## ASSESSMENT REPORT

### Building R1, Barangaroo South SSD 6513 MOD 3

This report provides an assessment of a section 96(1A) modification application lodged by Lend Lease (Millers Point) Pty Ltd (the Applicant) seeking to modify a State significant development application (SSD 6513) for the construction and use of Building R1 as a pub at Barangaroo South within the City of Sydney local government area. The application seeks approval for design amendments to the ground floor planter boxes, four signage zones and minor ground floor design and layout amendments.

Solotel – Barangaroo House
External signage

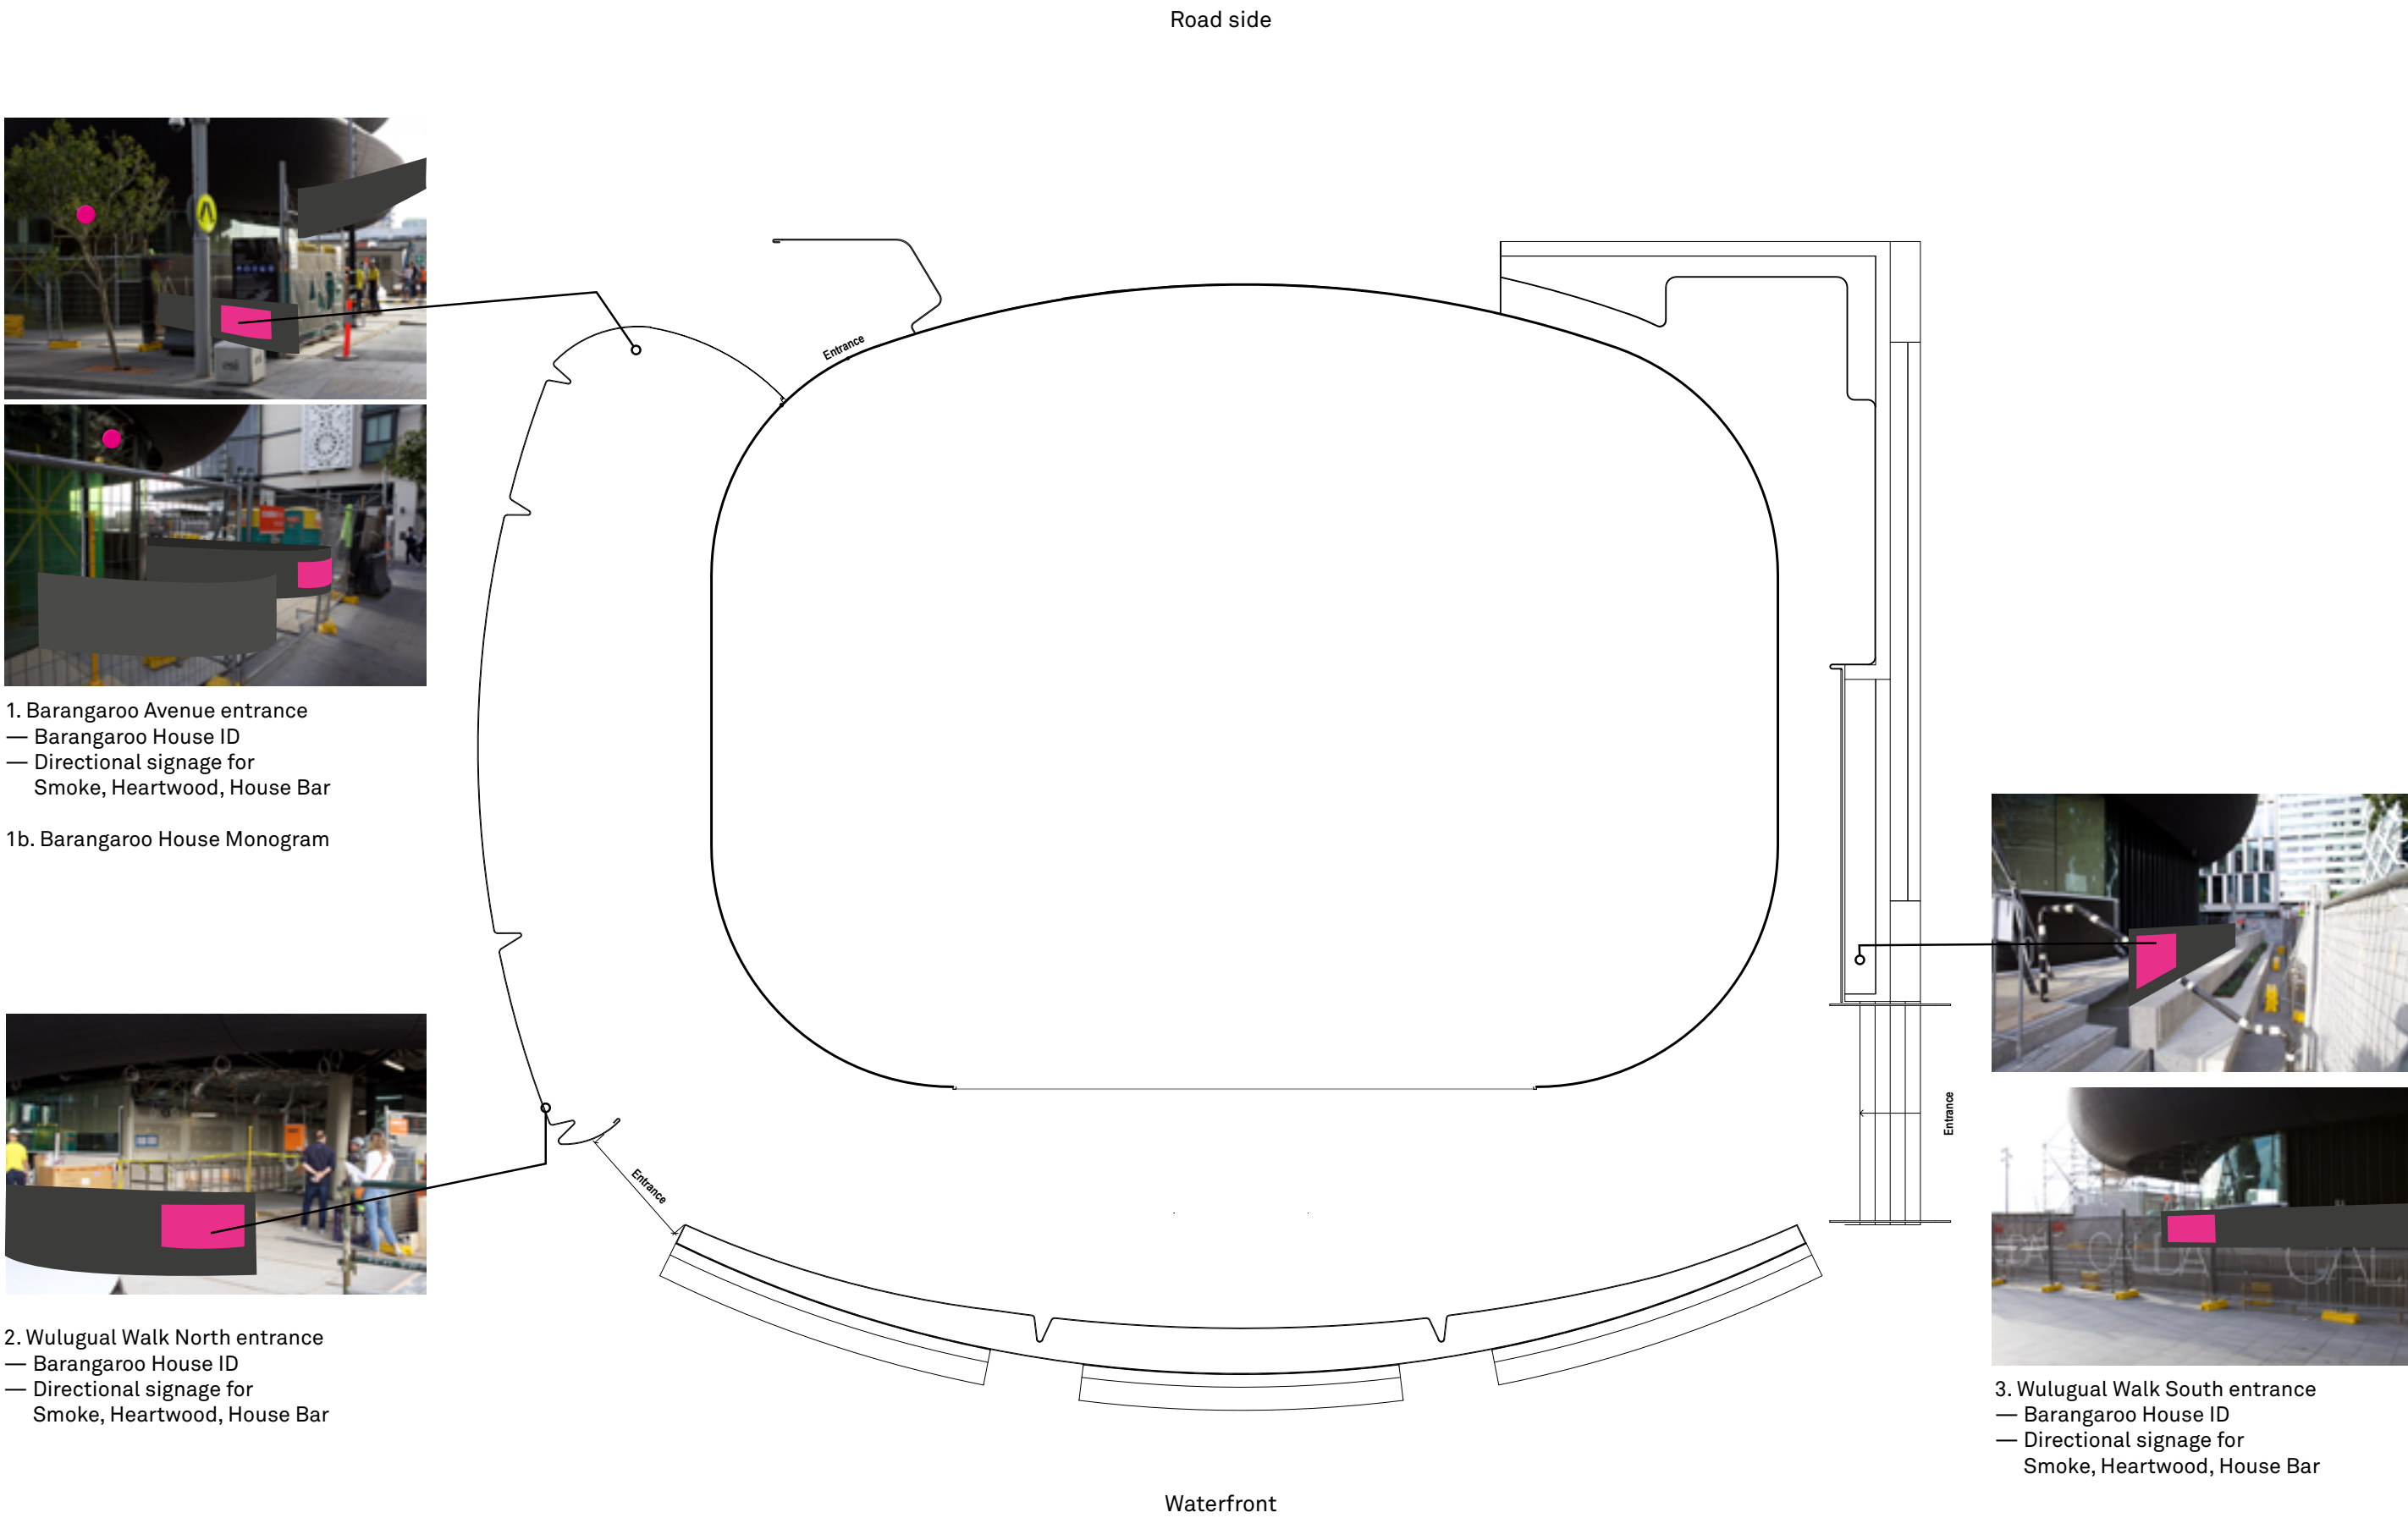
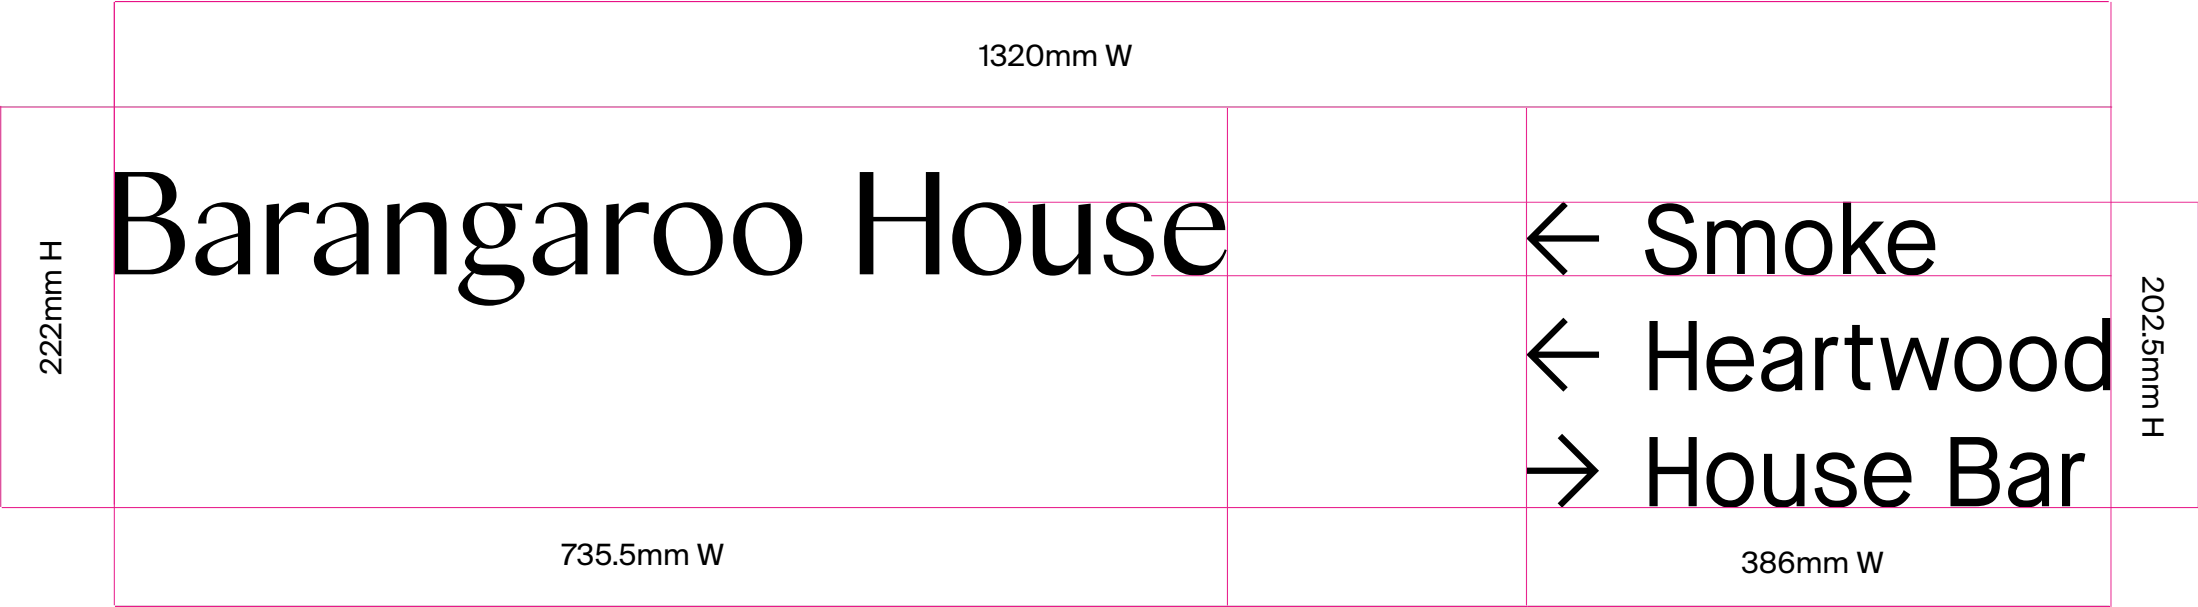
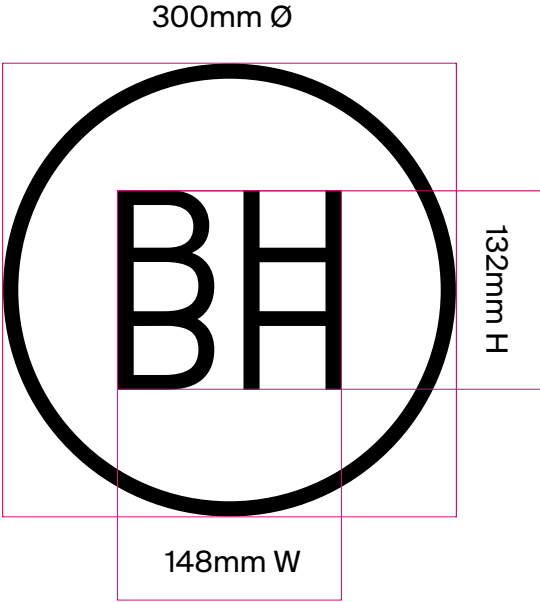
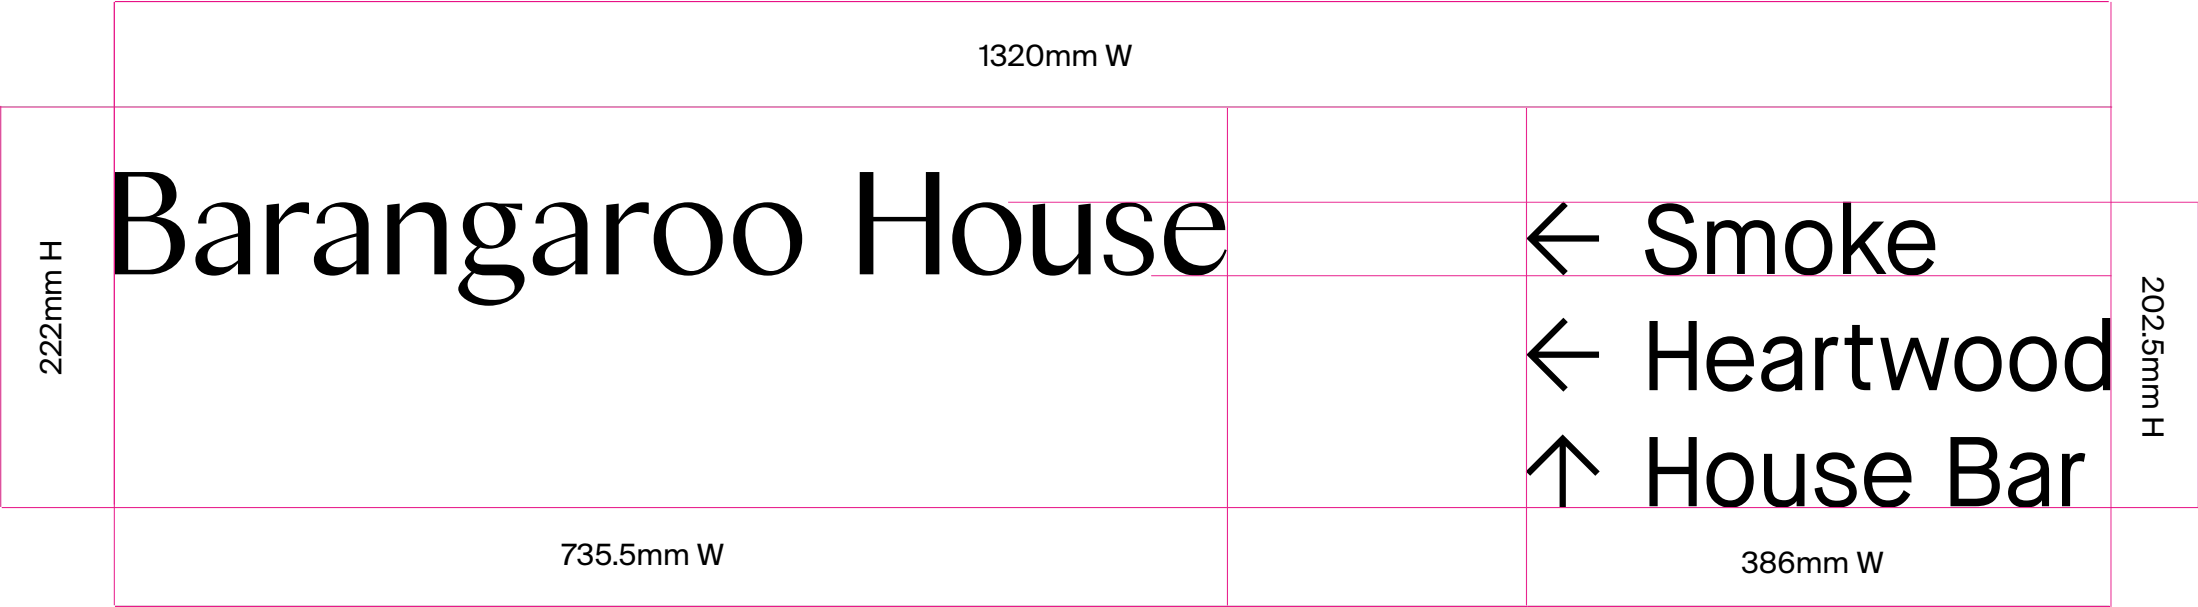
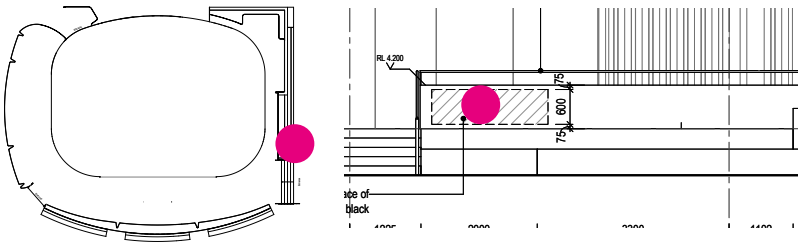
Council requested more detailed plans be provided showing how the proposed signage zones integrate with structures.

In response to Council's concerns, the Applicant provided concept plans 'for information' of the proposed signage (business identification and direction signage with backlit brass lettering) within the signage zones which demonstrate the signage would be flat mounted to the existing glazing (above the entry door) and the folded metal planters (**Figure 7**).

On review of the concept plans, the Department is satisfied the proposed signage zones would be suitably integrated into the design of the building. The detailed design of the signage, including the exact content, materiality and details of illumination, will be subject to separate development consent. Condition A11 of the existing consent requires the Applicant to obtain separate approval for the erection of signage.
